MEETING SUMMARY

SOUTH EVELEIGH HERITAGE SUB-PANEL

MEETING	Response to Submissions (RTS) for Modification request for Bays 5-15 of the Locomotive Workshops (8449 Mod 4)
DATE	Tuesday 14 January 2020
TIME	3:00pm – 4:00pm
VENUE	Mirvac Site Office, Yerrabingin House, Level 1, 2 Day Road, Eveleigh

Figure 5 | Proposed location of the sliding glazed barrier on gridline 8

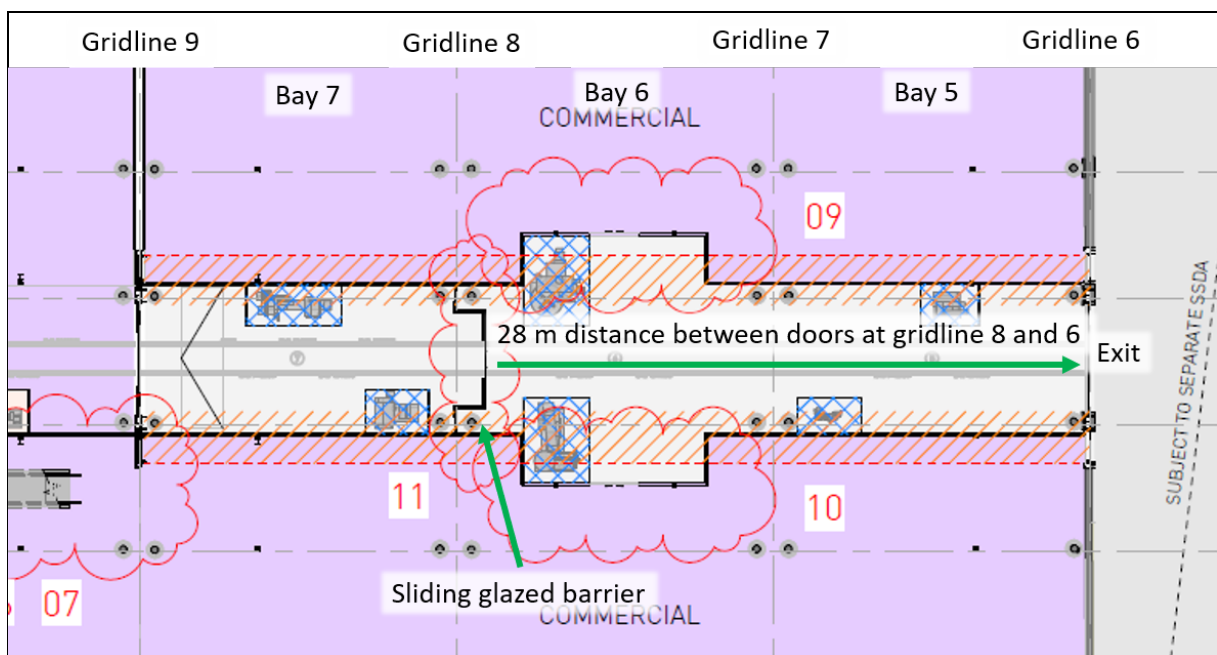
ITEM	ACTIONS
1. Welcome and introductions	
	PW opened the meeting and welcomed everyone.
2. Bays 5-15 of the Locomotive Workshops (8449 Mod 4)	
	PW provided an overview of Modification 4 of the State Significant Development (SSD) Modification Application for the ATP Locomotive Workshop Bays 5-15.
3. Comments Received RTS1 – Gridline 8 Sliding Door	
	PW provided an overview of the proposed sliding door along gridline 8 in Bay 7. - The proposed sliding door is the threshold between the retail and commercial areas. - The sliding door is required ensure that the design of Bays 5-15 of the Locomotive Workshop complies with the BCA, which requires that members of the public must be within 20m of a point of choice egress

(under the current configuration, the distance between Gridline 6 and the door on Gridline 9 Door is approximately 50m). Under the fire engineering strategy for the base building, an alternate solution permits this door to be located at no greater than 28m from Gridline 6. - The proposed sliding door has been designed to minimise any obstruction of views along the central spine of the Locomotive Workshop, with a semi-frameless glazing and only structural head supports. Curio Projects confirm that the proposed sliding door will have an overall neutral visual impact, generally consistent with SSD 8449. Discussion: - AR – BCA regulations require three points to an exit. - DN - concerned that it introduces another barrier. We originally discussed it being a low height barrier - it's now morphed into a full height barrier that has considerable visual impact. - DN - what are the alternatives? - US - we need the point of choice. There are other solutions, but there is a significant impact on the design and use if the tenancy space. - DN – <i>[refers to floor plan]</i> that area is not part of any tenancy - what would you define this space as? - AR - tenants from Quantum could use this section. - DN - can the Quantum tenancy wall be removed? - AR - high-level glazing will still be required. We're trying to get the best outcomes for everyone and make the barrier as delicate as possible. - DN - could you lower the barrier? - AR - yes. - NV - are you suggesting that we extend the tenancy so that there is only one entry? - US - depends on who the final tenant will be, and how much area they want. There is still the option for there to be two separate tenants. - DN - preference on gridline 8 is for here to be a low-height security barrier rather than a full-height barrier. - NV - sometimes you get dispensation for heritage assets. David - any examples? - DN - we have examples for dispensation of entries to heritage assets. - DN - can you remove the metal lintel of the entrance? - AC - it's as low and as subtle as it can be. - AR - we could drop it to the floor. - AR - we can consider other entrance styles. i.e. a low gate driven by a motor above. - DN - access is of a lesser concern to me than visual impacts. - DN – we will investigate if there is the possibility of some dispensation for heritage assets. - NV - let me know if there is any other precedent. - US - we are required to restrict public access. - PM - will the barrier have to be closed at all times? - US – yes.

- PW – so we have two options. One is to seek dispensation for BCA requirements, another option is to investigate a low-height barrier. - US - are you ok with these two options? - PM - yes. - DN - yes.	Mirvac to investigate whether there could be any dispensation for BCA requirements for heritage reasons.
